# CITY OF ALBUQUERQUE

Planning Department  
Alan Varela, Director

**Re: Sandia Collision**  
**1515 Yale Blvd. SE**  
**30-Day Temporary Certificate of Occupancy**  
**Transportation Development Final Inspection**  
Architect's Stamp dated 06-29-21 (L15-D063)  
Certification dated 11-17-23

SANDIA COLLISION 73X60X19
1515 YALE BOULEVARD, SOUTHEAST
ALBUQUERQUE, NEW MEXICO

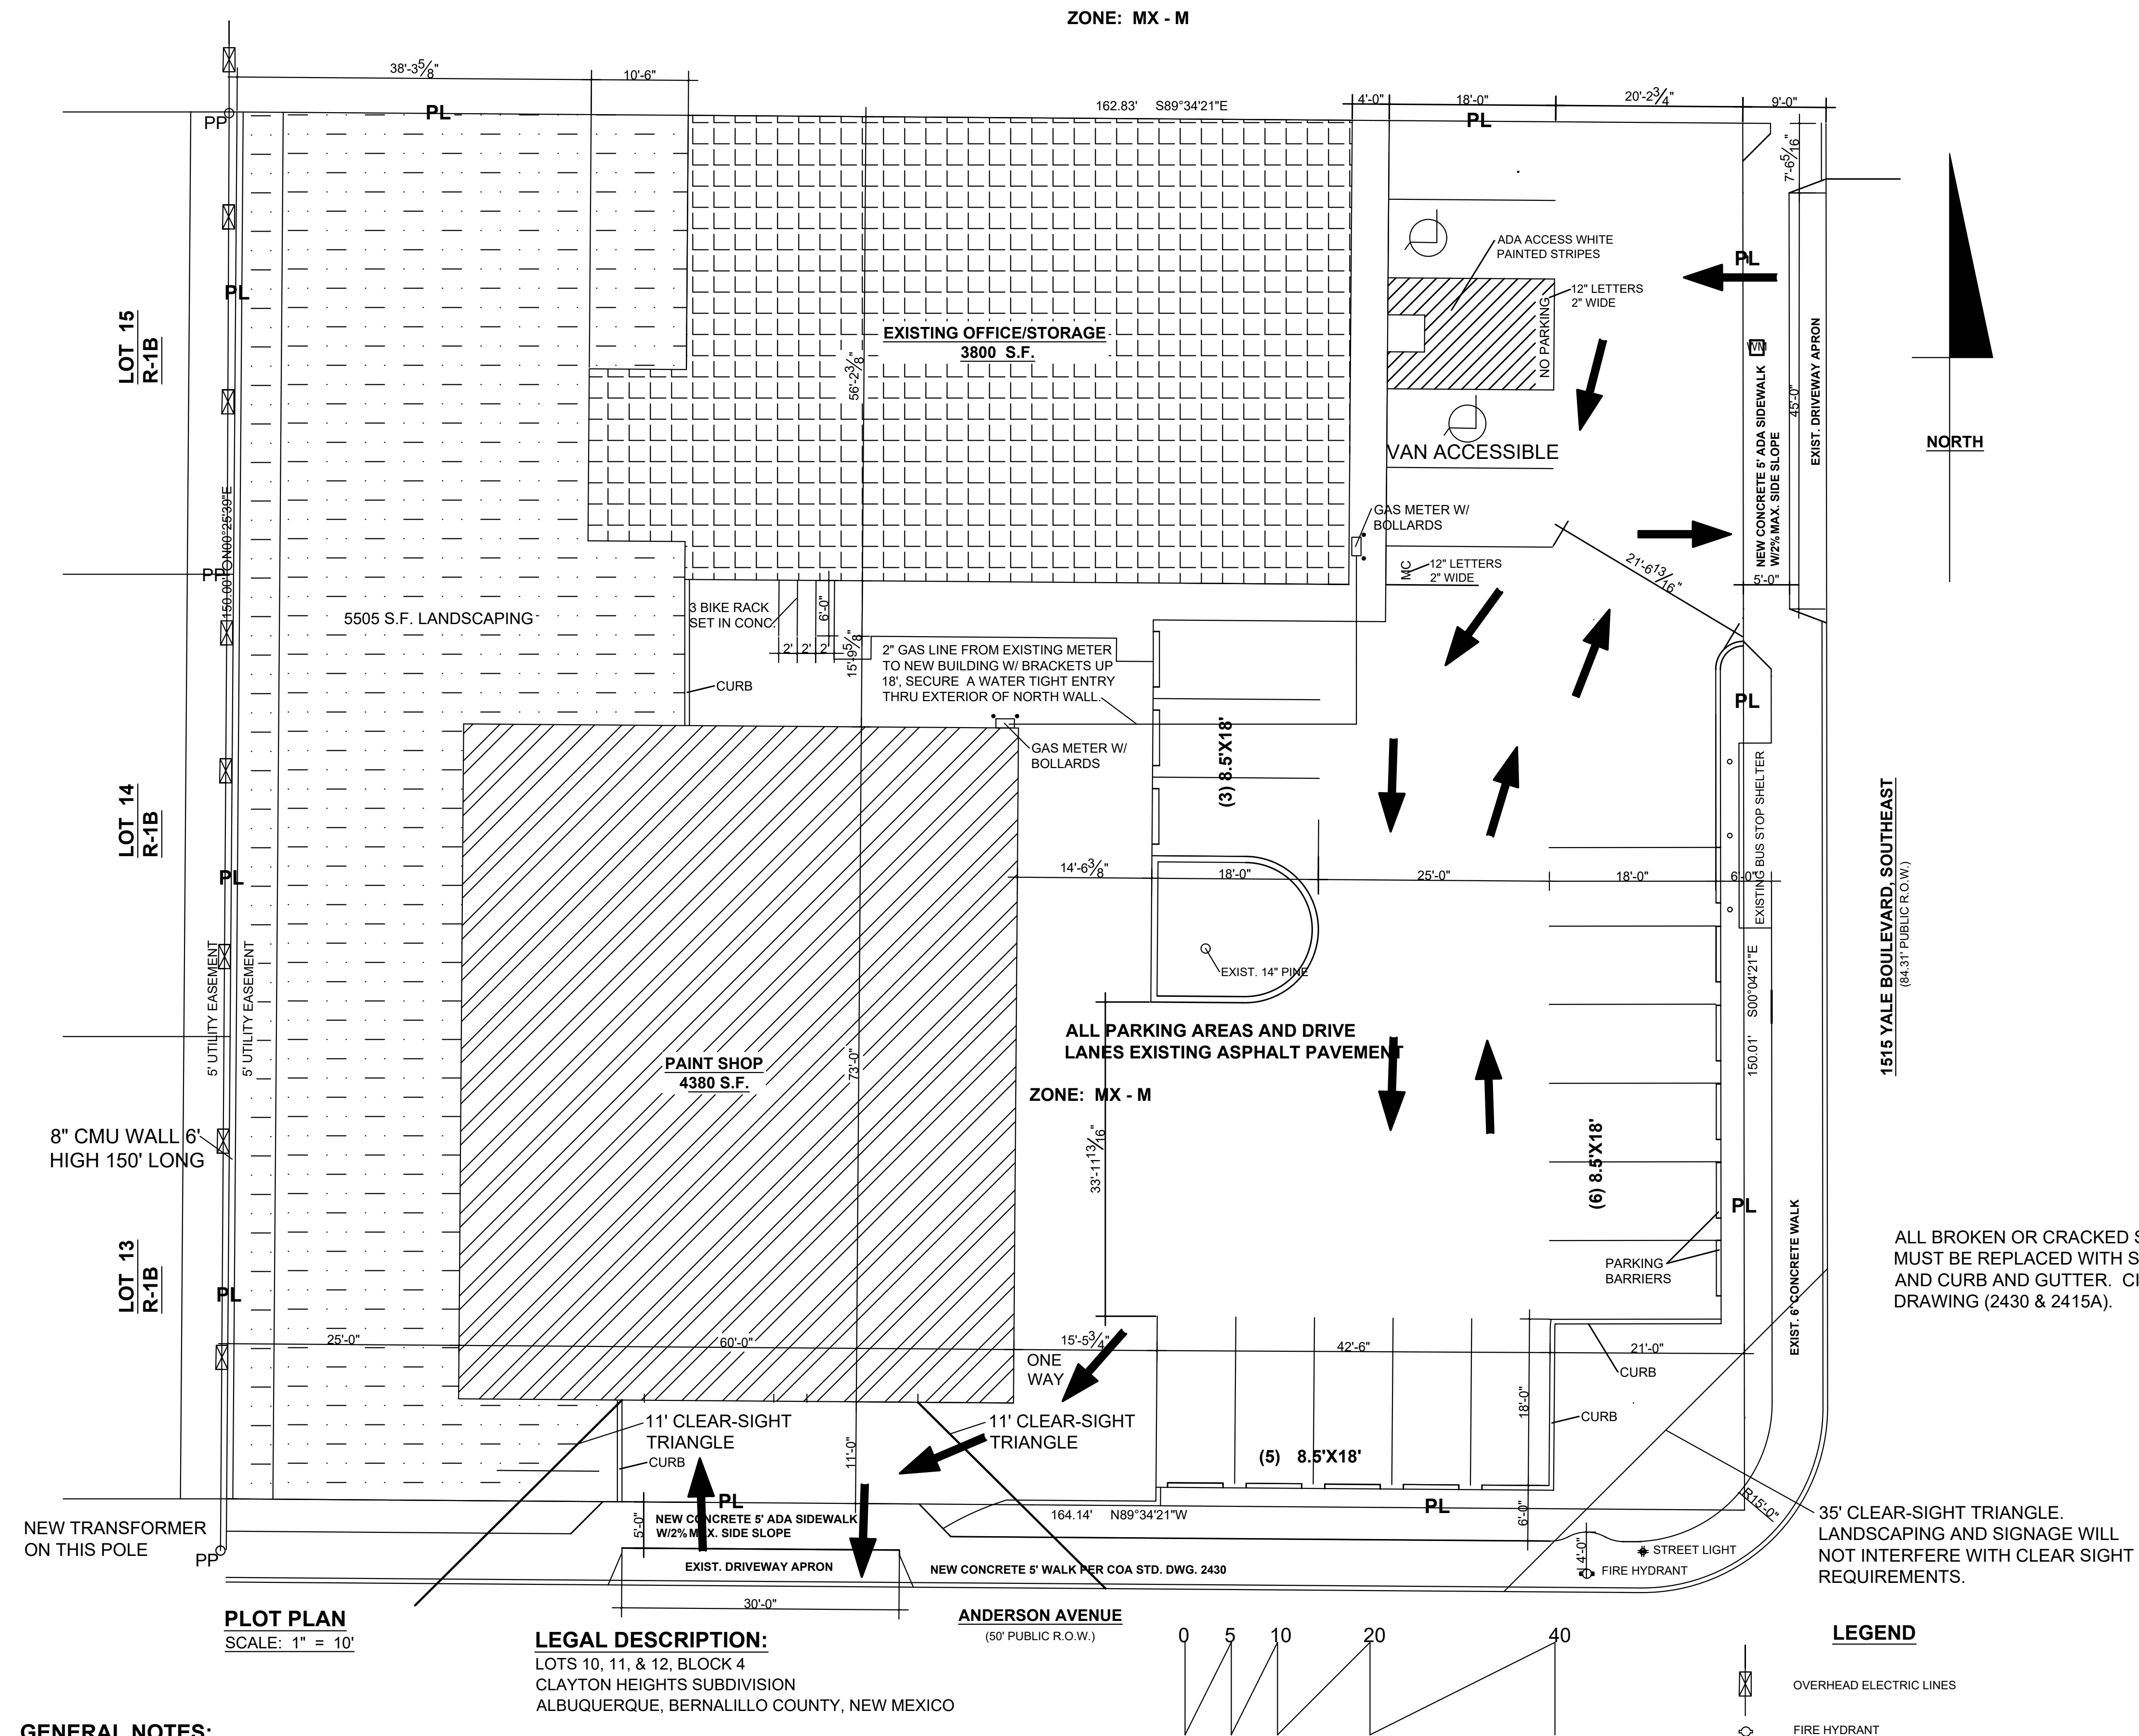
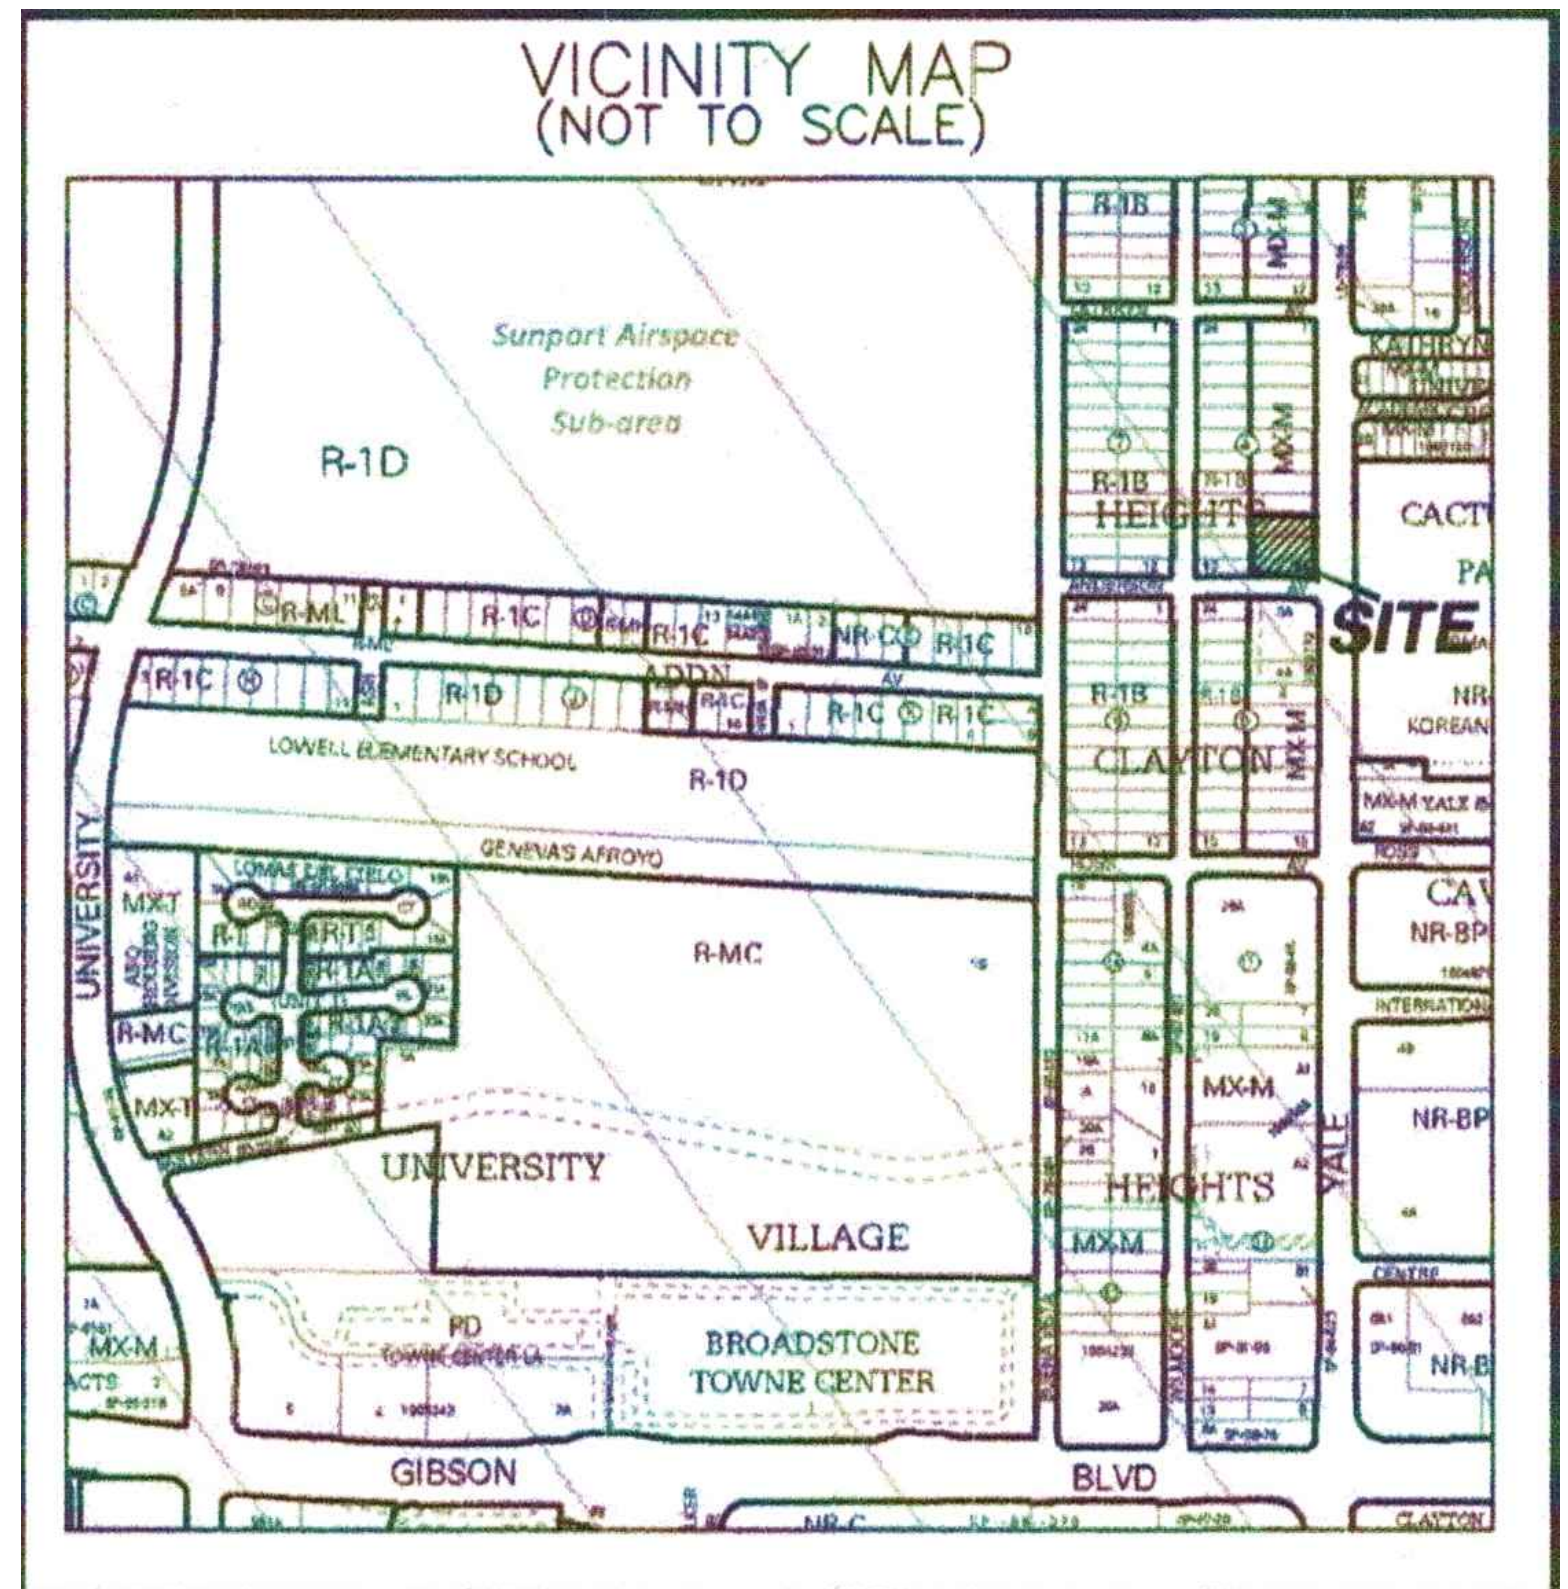
- The ADA accessible parking sign must have the required language per 66-7-352.4C NMSA 1978 **"Violators Are Subject to a Fine and/or Towing."** Please call out detail and location of signs.
- The ADA access aisles shall have the words **"NO PARKING"** in capital letters, each of which shall be at least one foot high and at least two inches wide, placed at the rear of the parking space so as to be close to where an adjacent vehicle's rear tire would be placed. (66-1-4.1.B NMSA 1978)

- Per approved plan, 3 regular parking spaces in this area. Please remove the extra MC parking space to ensure provide an adequate parking space.

- Please provide Motorcycle parking sign.
